Resubmission for Building Permit

King Residence
Jonathan Culley – Contractor of Redfern Properties LLC.
2011-07-1749-sf
24 Torrey Street CBL: 156 – C- 004-001

REVISION 9: 08/05/11 ADDED PROPOSED BAY STREET UTILITIES
 REVISION 8: 08/05/11 ADDED BAY STREET UTILITIES
 REVISED 07-31-2011: ADDED PROPERTY CORNERS TO BE SET
 REVISION 6: ADDED PROPOSED UTILITIES, NOTES AND OFFSET DISTANCES.
 REVISION 5: ADDED PROPOSED HOUSE AND ENCROACHMENTS

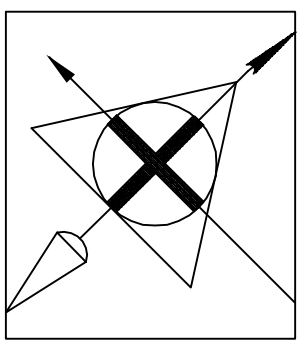
- A revised Survey is submitted that is to scale
- A vicinity map has been included on the survey
- A revision block has been included
- Property Markers and proposed building locations are being set at this time by Robert T. Greenlaw, Surveyor.
- Vertical Datum note has been included
- The survey now shows the tie to nearest street line and monument
- Street status is now included

JOB: 2011003
 ISSUE DATE: 08/08/11
 PRINT

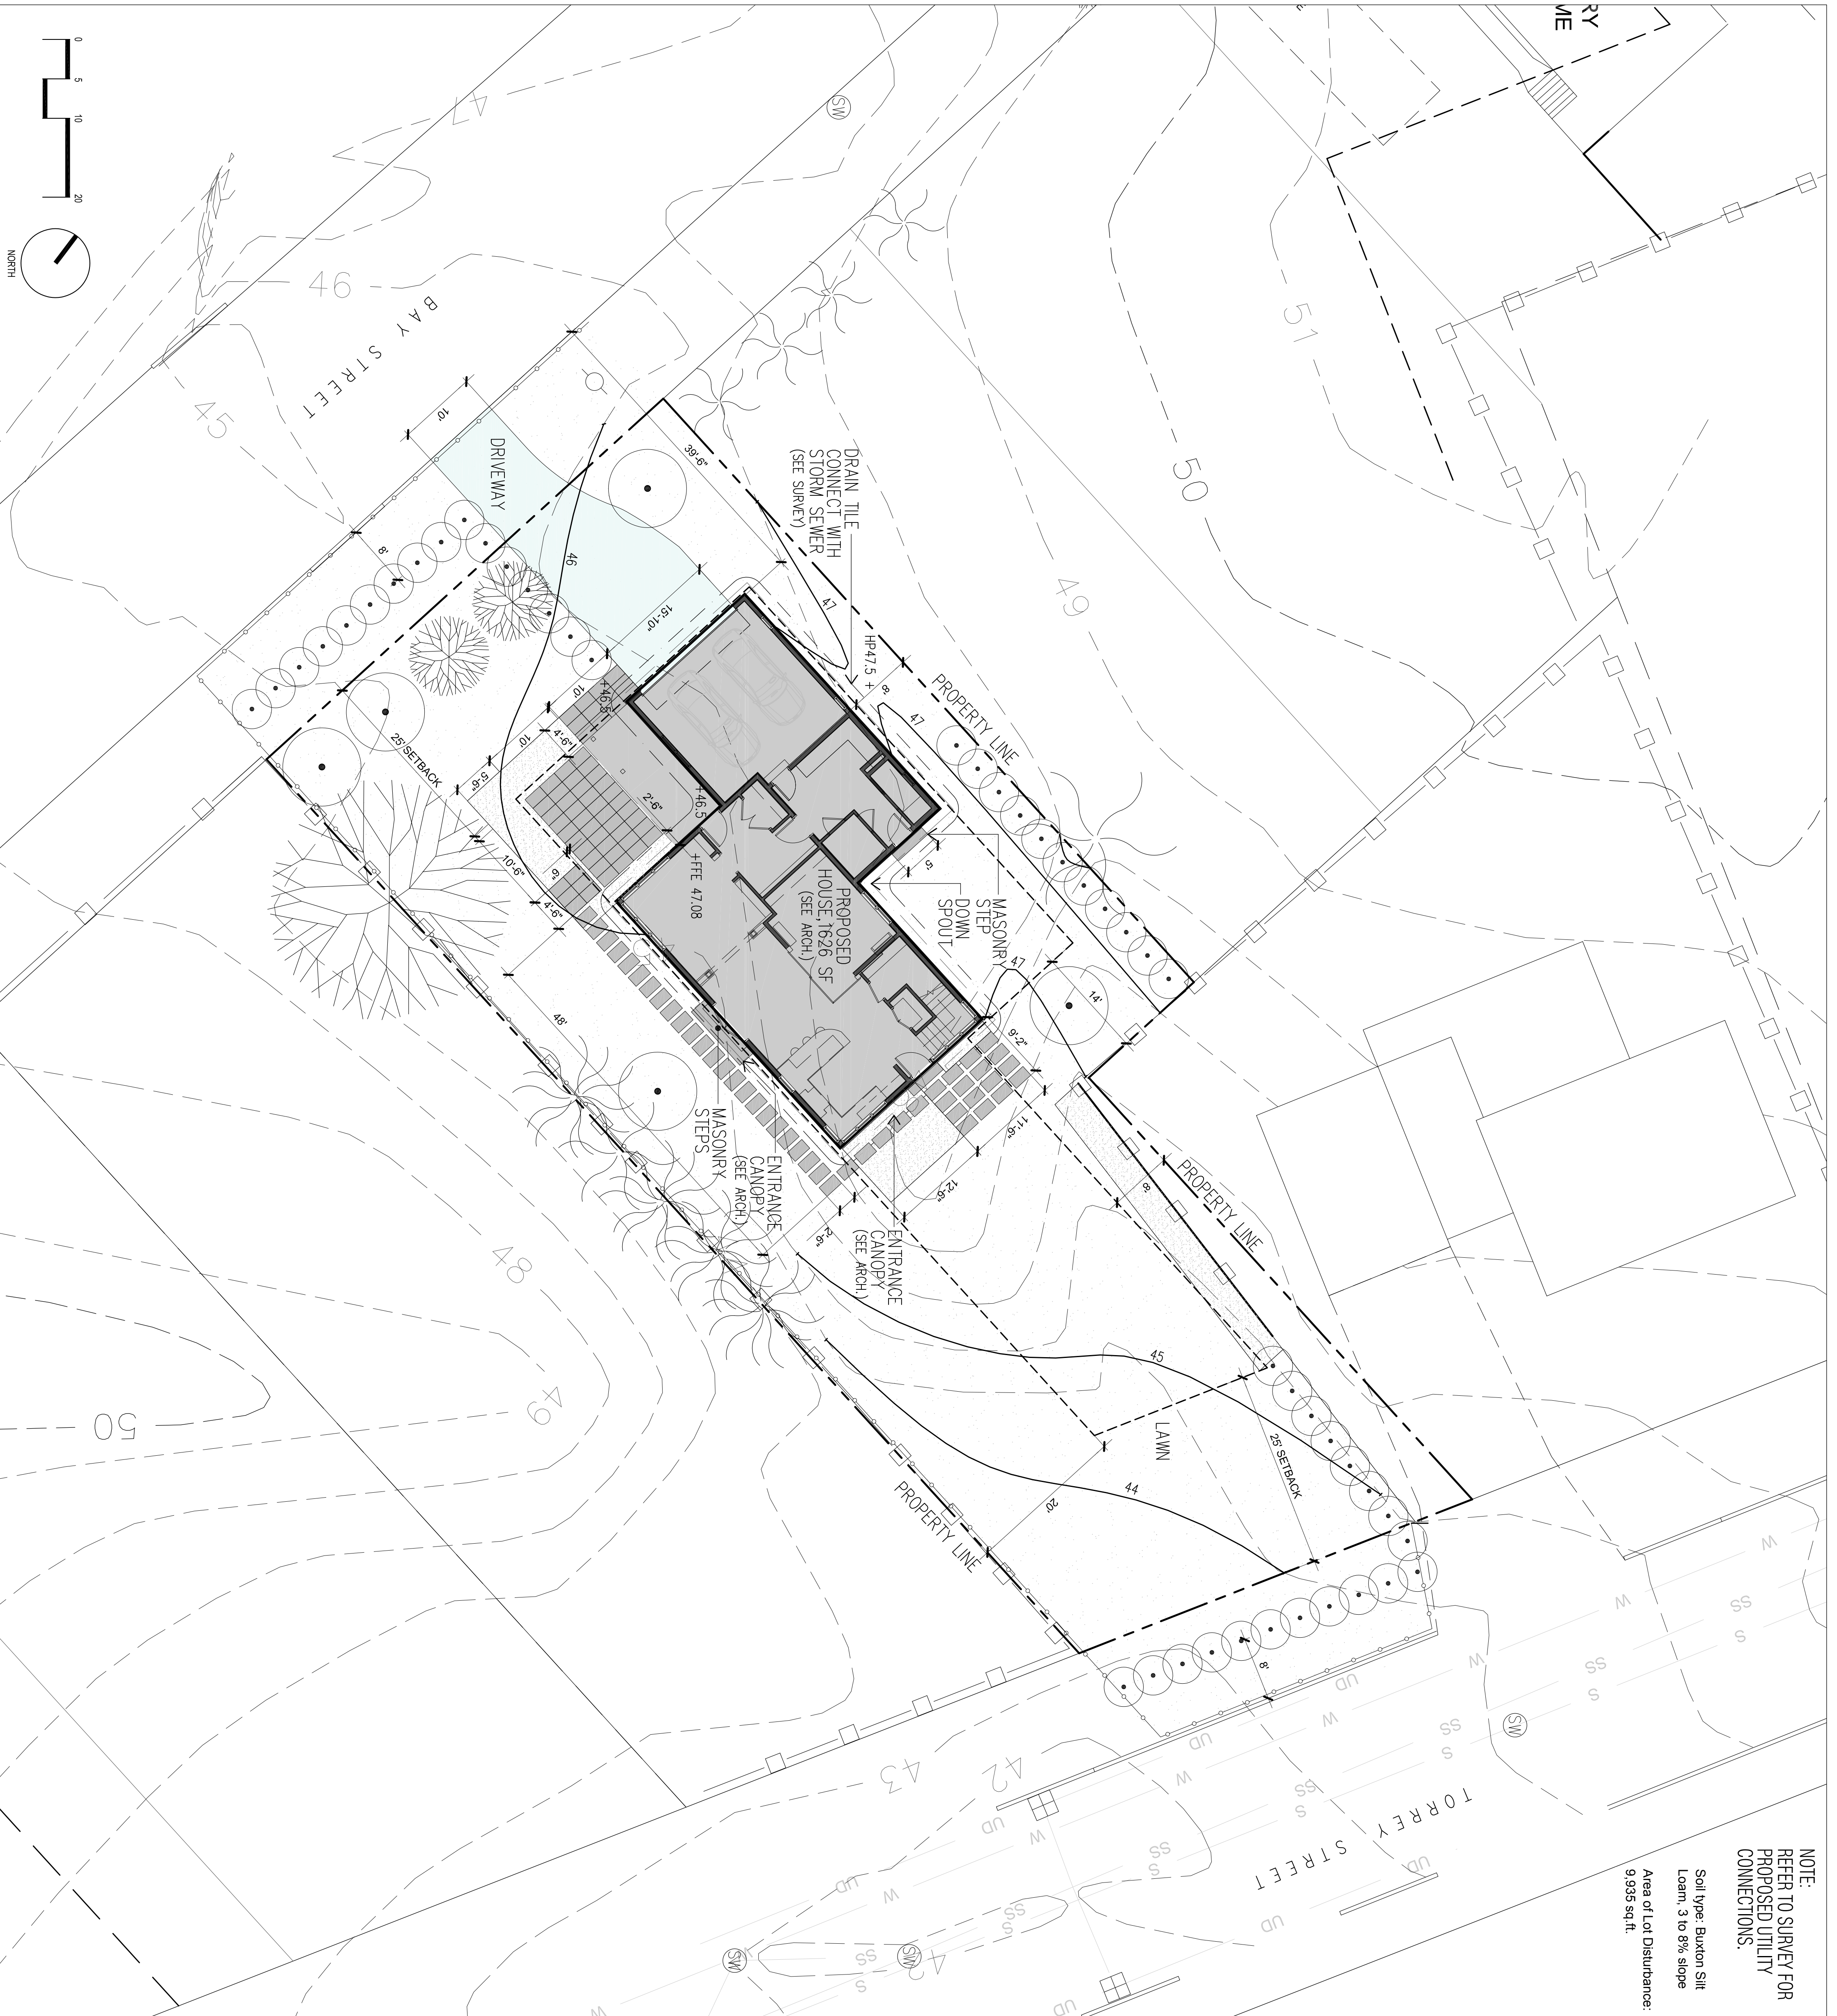
- The reconfigured roof line has been reviewed by the zoning department and the house has been determined to be a 2 story structure. Therefore the resubmitted drawings show the setbacks that reflect a 2 story building.
- Drive is shown on the plans and the resubmitted site plan shows additional dimensions.
- Ground floor elevation is labeled on the site plan
- This was on the original plan and remains on the resubmission. The Label "+FEE 47.08'" indicates First Floor Elevation of 47.08'
- Existing and finish contours are shown (existing are dashed) They continue to be shown on the resubmission.

- A silt fence linetype has been added showing the bounds of the erosion control silt fence. It will be along the downhill property boundaries.
- The home will have a perimeter dripstrip and a perimeter drain tile that will connect to the storm sewer in Bay St. There is also one downspout located at the northern re-entrant corner of the house and garage wing. This will be tied to the perimeter footing drain.
- Area of disturbance is noted on the siteplan
- Soil type is noted on the site plan.
- Perimeter footing drain is now shown
